FP/22/07

PLANNING APPLICATION REPORT

DESCRIPTION/ ADDRESS	- Conversion of existing roof space to form an additional self contained flat (re-submission of FP/256/06) 12 Limmer Lane, Felpham
-------------------------	--

WEST ELEVATION (other elevations as existing)

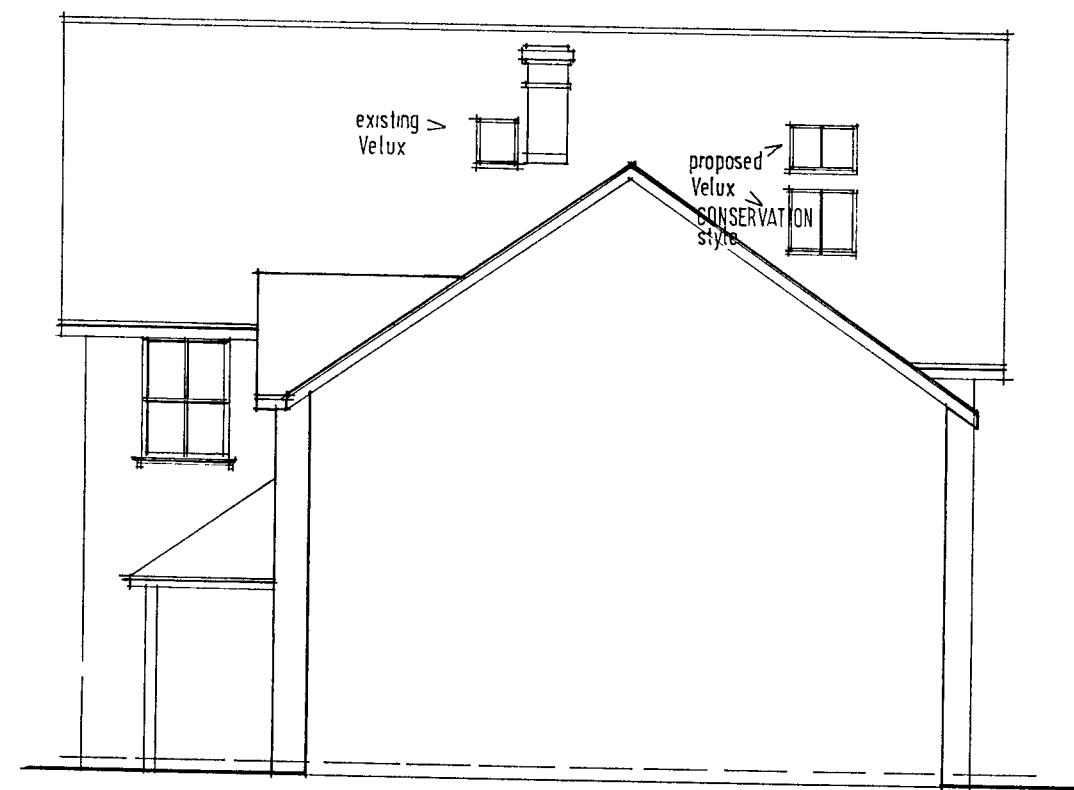
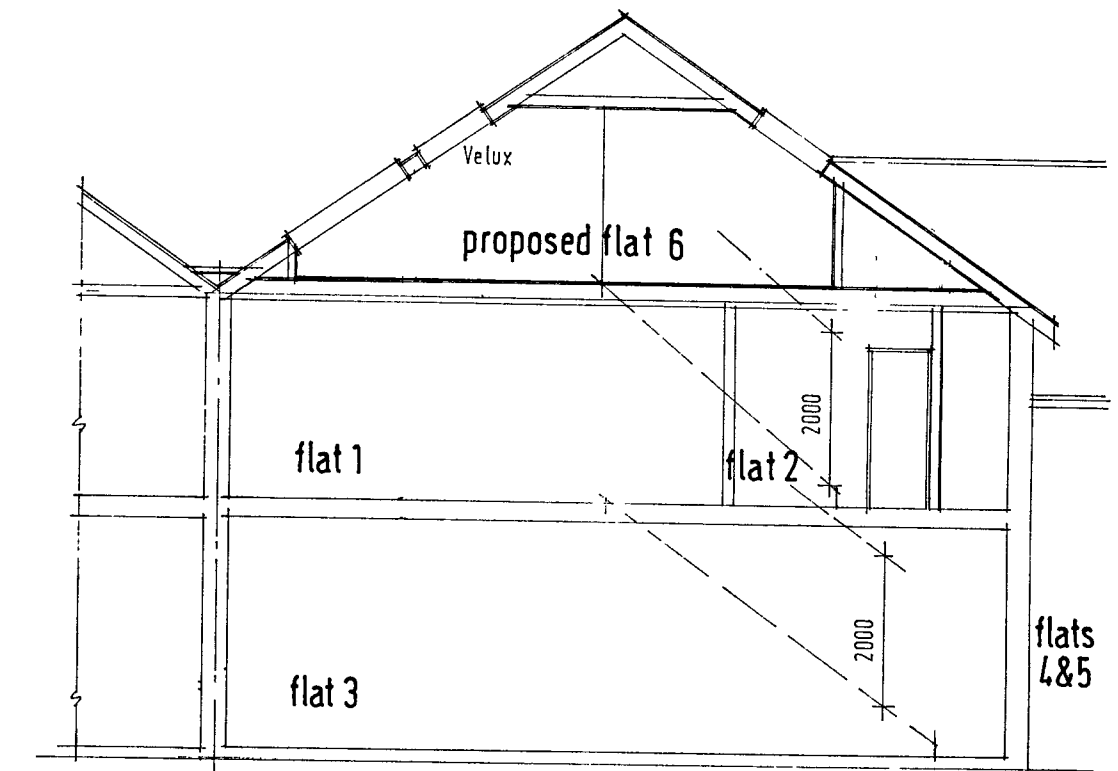
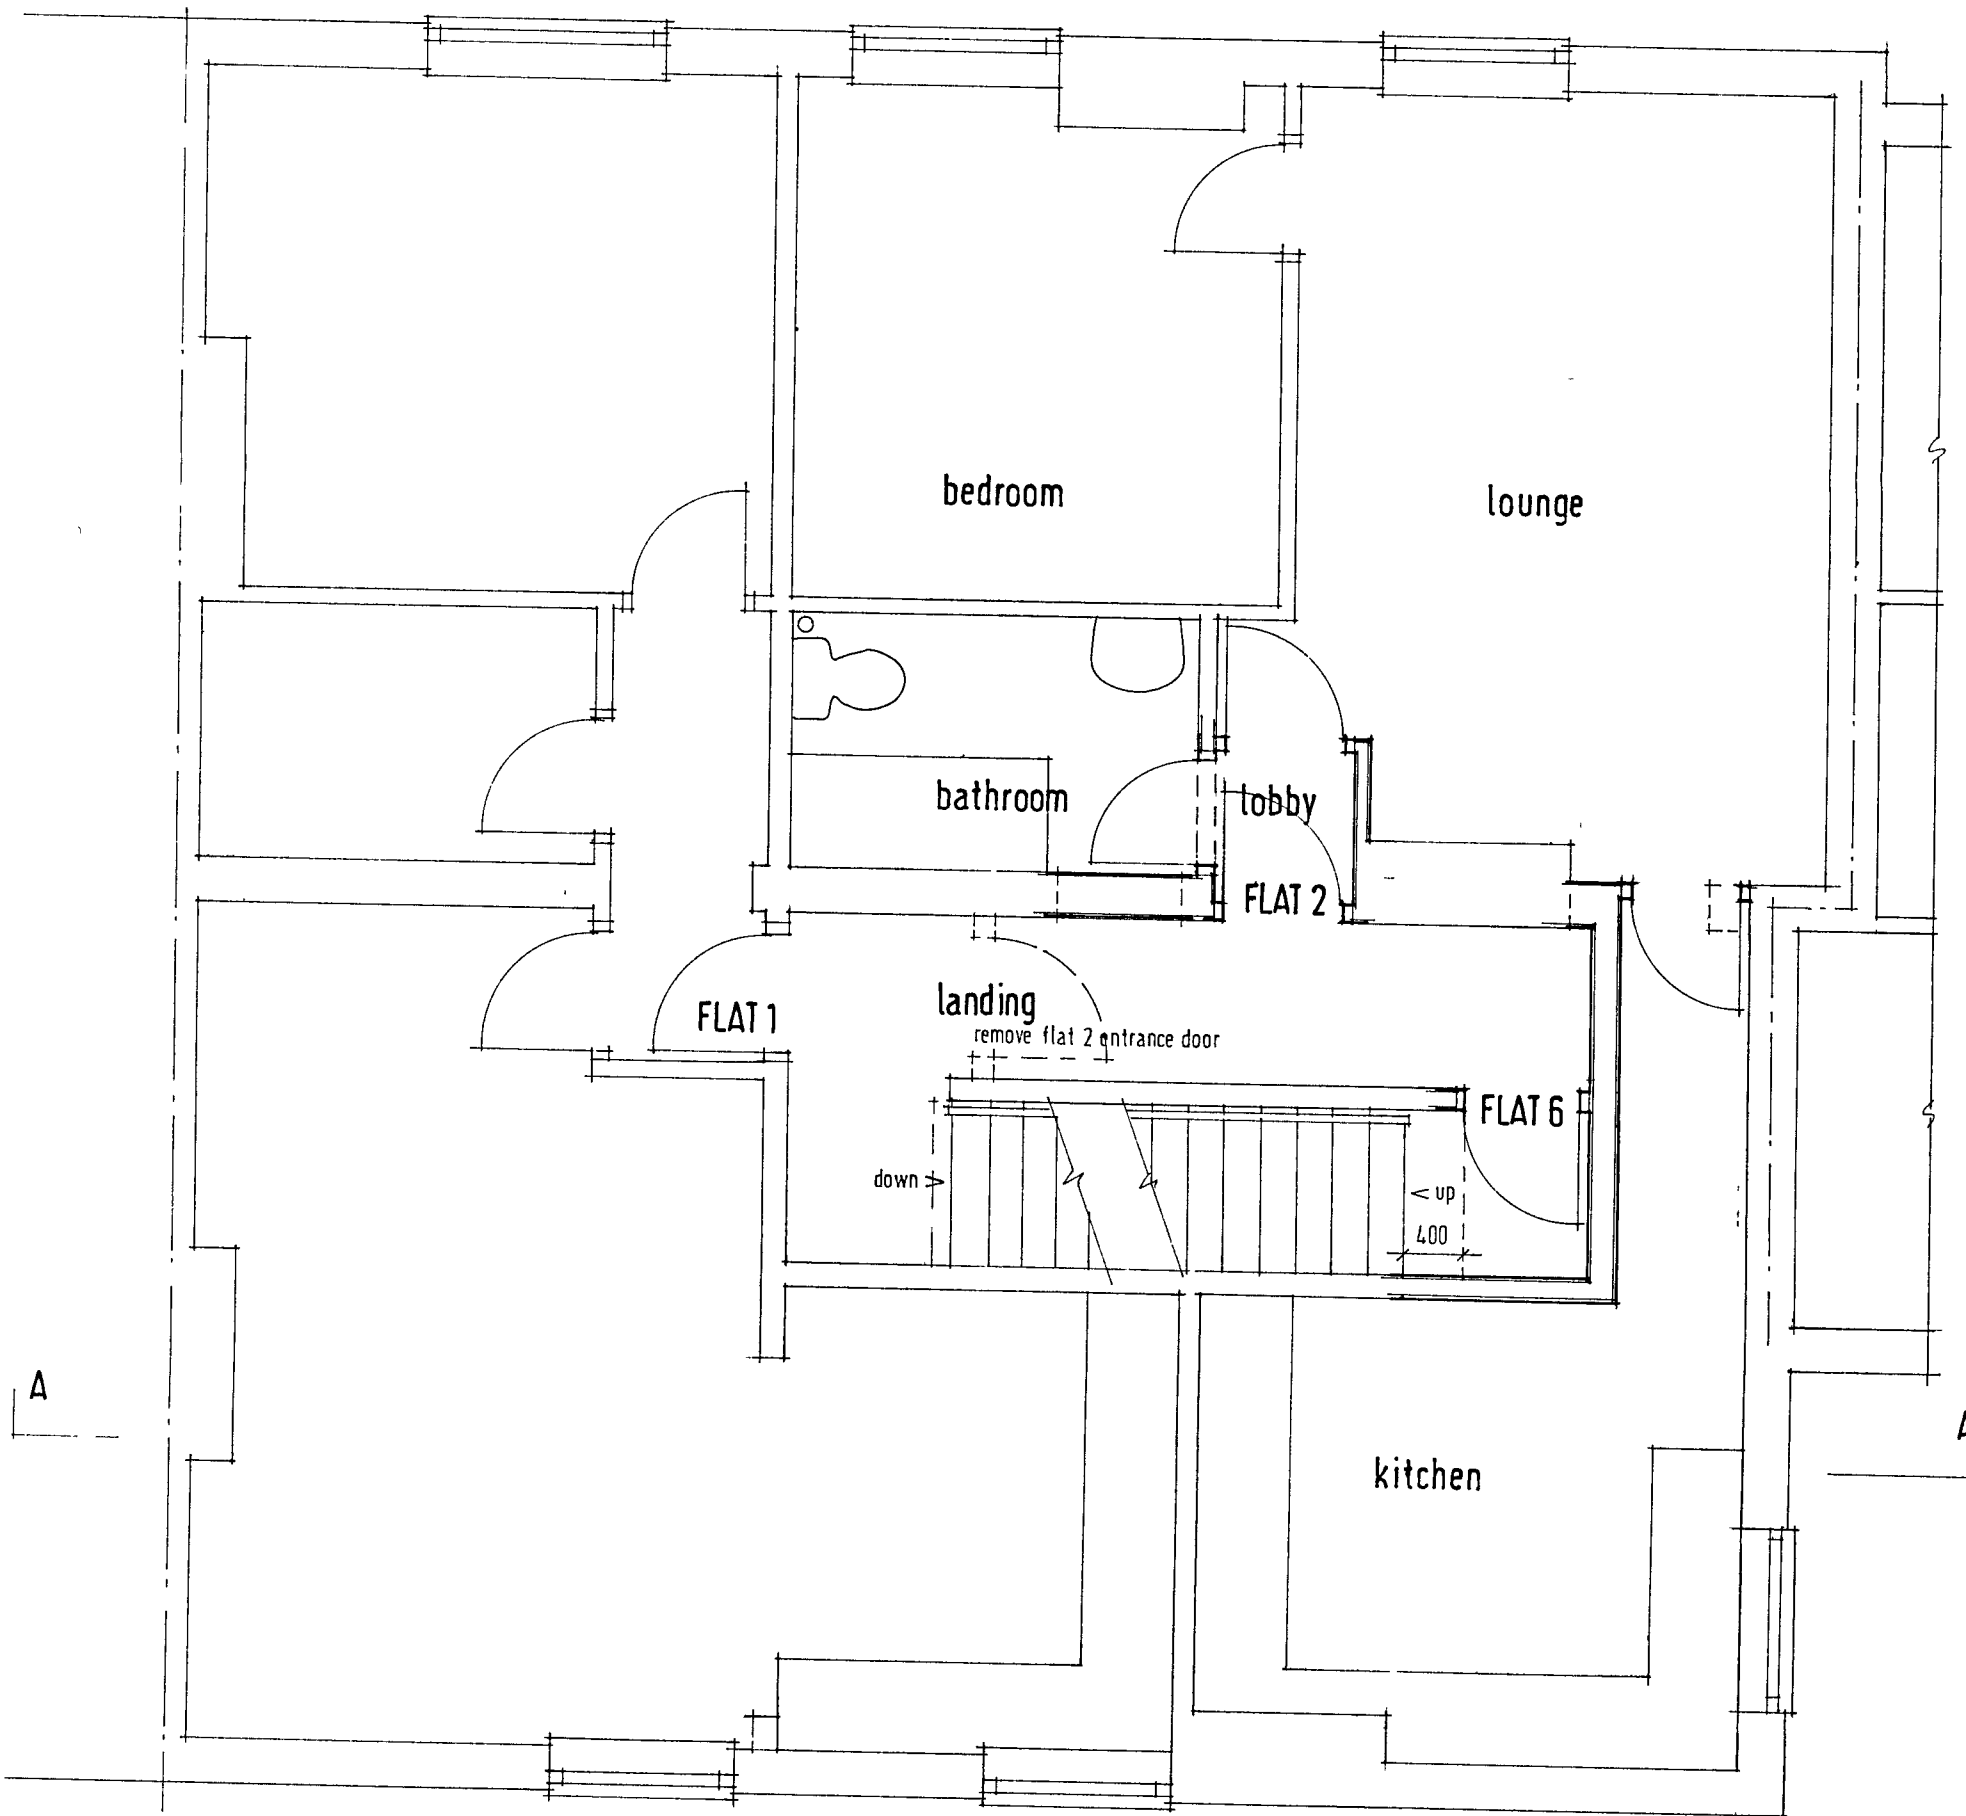
CONSULTEE	SUMMARY OF RESPONSE
County Highways	No objection
Conservation Officer	This is a significant reduction in the number of rooflights on the prominent west slopes of the roof. There will be no adverse effect on the character or the appearance of the Conservation Area.

The number of rooflights has now been reduced on the western roof slope to an acceptable level. They would not be obtrusive in the street scene and would be located to the rear of the roof slope where they would not be readily visible. There would be no adverse effect on the character or appearance of the Conservation Area.
